From: BRYAN BUTCHER [REDACTED]
Sent: 13 May 2020 10:03
To: Nicola Moore
Subject: Re: Request for further information AW/109/20/HH
Attachments: 16, Barrack Lane Planning Amendment Sheet 2a of 5 .pdf; 16, Barrack Lane Planning Amendment Sheet 5 of 5 .pdf

sheet 1 of 5

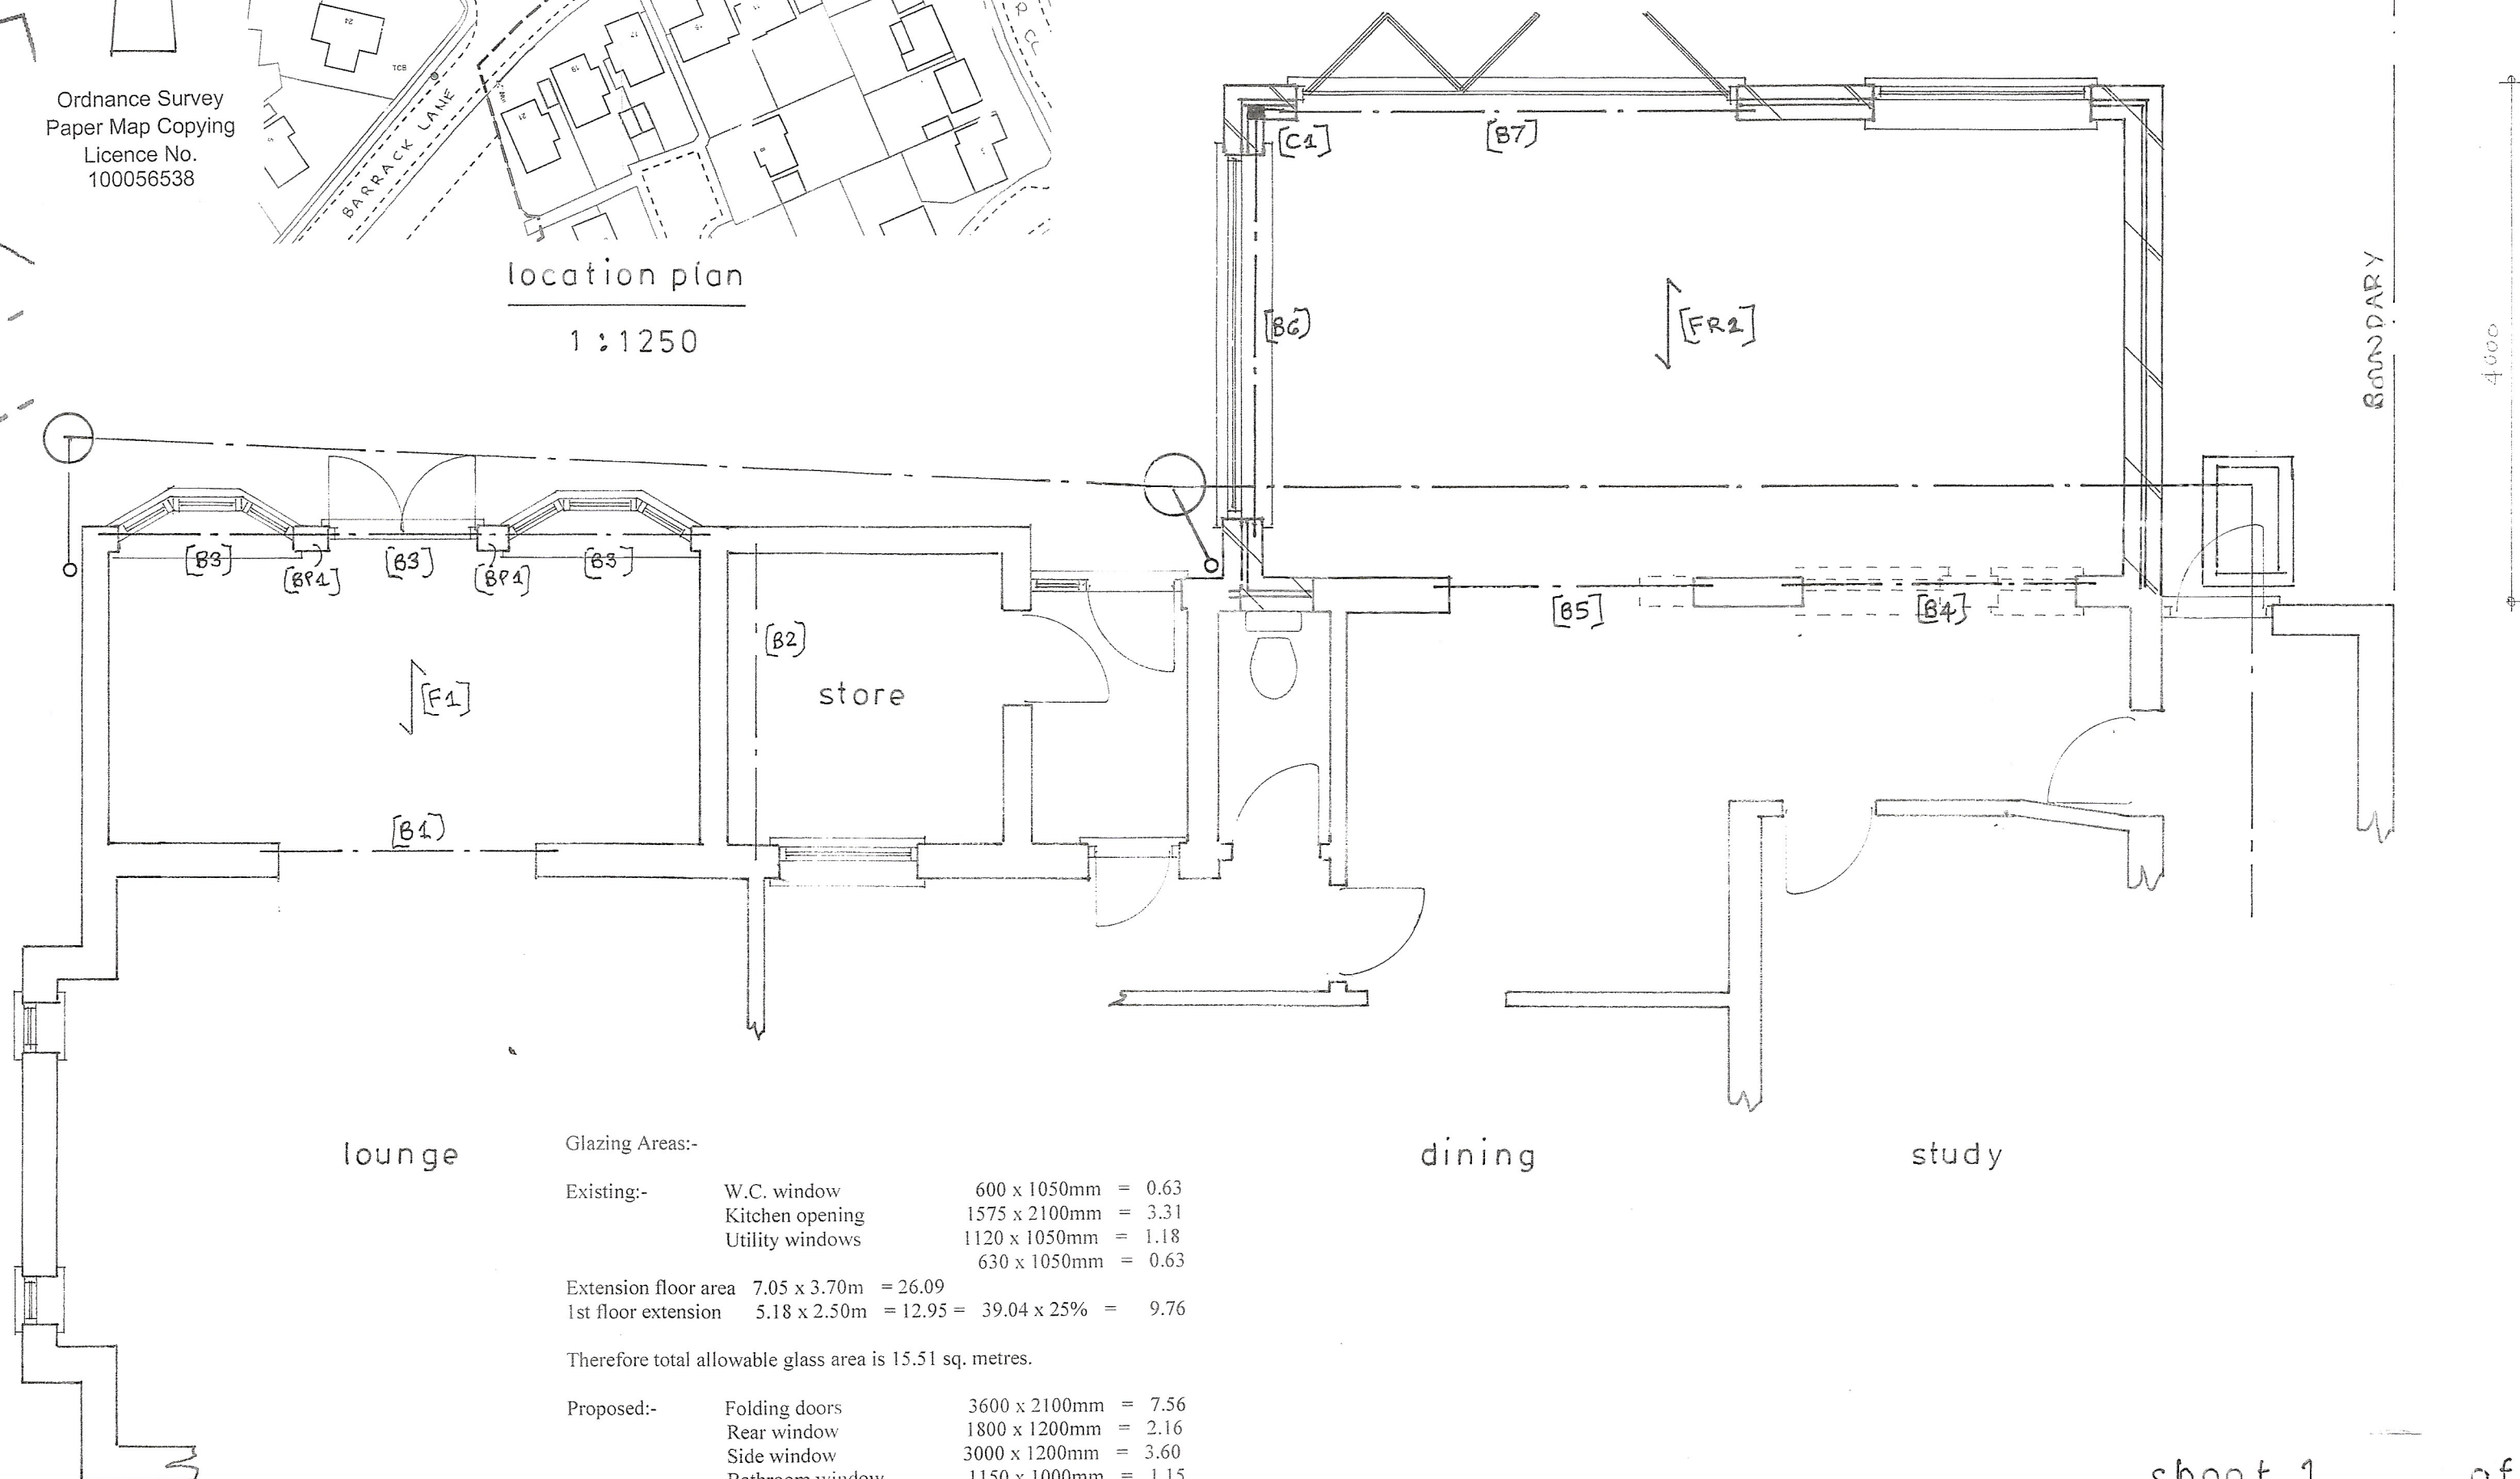
With regards to the Ground Floor extension, I have now checked these with Daun and a planning officer. We have measured the width of the ground floor extension on sheet 1 of 5, at 7.55m, the scale shown for this is 1:50, however, when the width of the ground floor extension is measured on sheet 2 of 5, it is 3.8m and the scale shown is 1:100. On the Block Plan, the measurement of the width of the ground floor extension, at a scale of 1:500 is 7.45m

Proposed rear extension elevation (ground floor) at 1:100
floor) at 1:50

Proposed rear extension floor (ground

Door = 3.50m

Window = 1.74m

Width = 7.60m

The width of the single storey rear extension is 7.55 metres.

There may be small discrepancies between plan, elevations and block plan due to the scanning process and the thickness of nib I draw with particularly on the block plan.

sheet 2a of 5

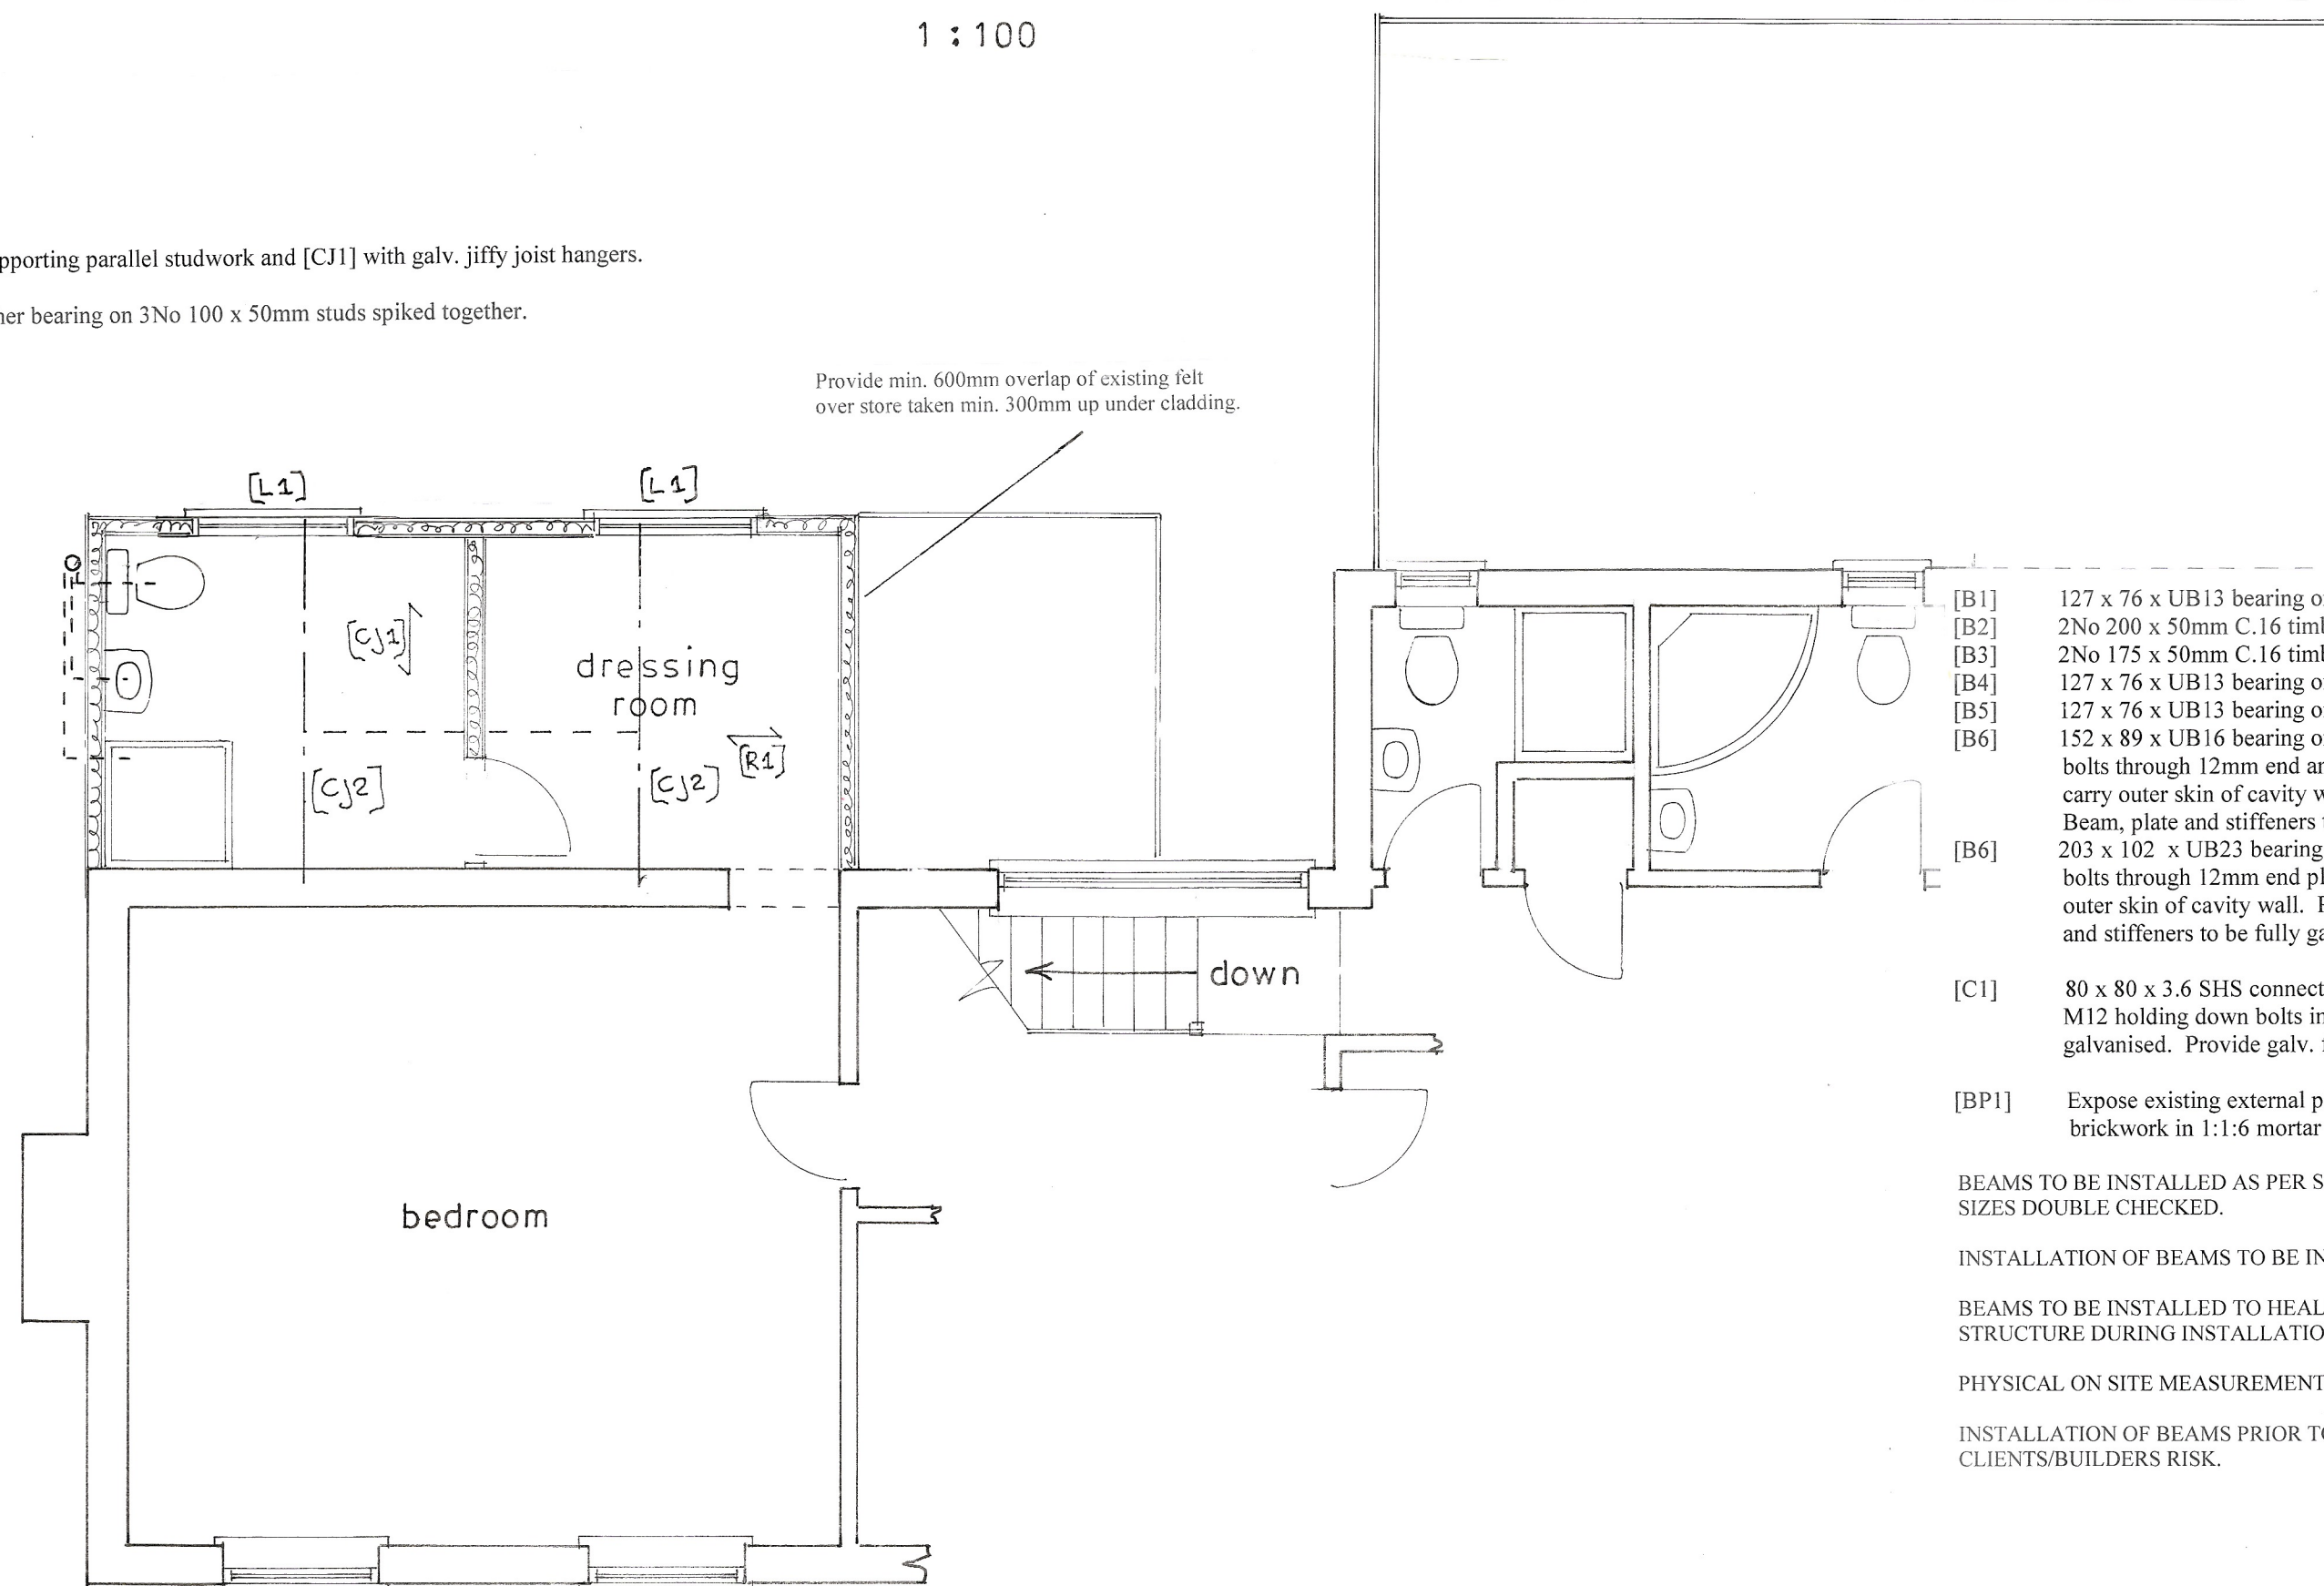
Thank you for the amended Car Port elevations. Apologies for any confusion, the elevations I was referring to in my email of 6th May, are the main house. Please can you check the North, South & West aspect elevations, as we believe the elevation currently labelled West, should be North. Please amend accordingly, and re submit.

In the meantime, please could you confirm the North, South and West aspects on the Proposed elevations are correct, as on checking we think the West elevation should be North, and the sides West and East?

Door = 1.78m

Window = 0.89m

Width = 3.81m

Following our telephone conversation I am pleased to attach the amended plans Sheet 2a of 5 and Sheet 5 of 5
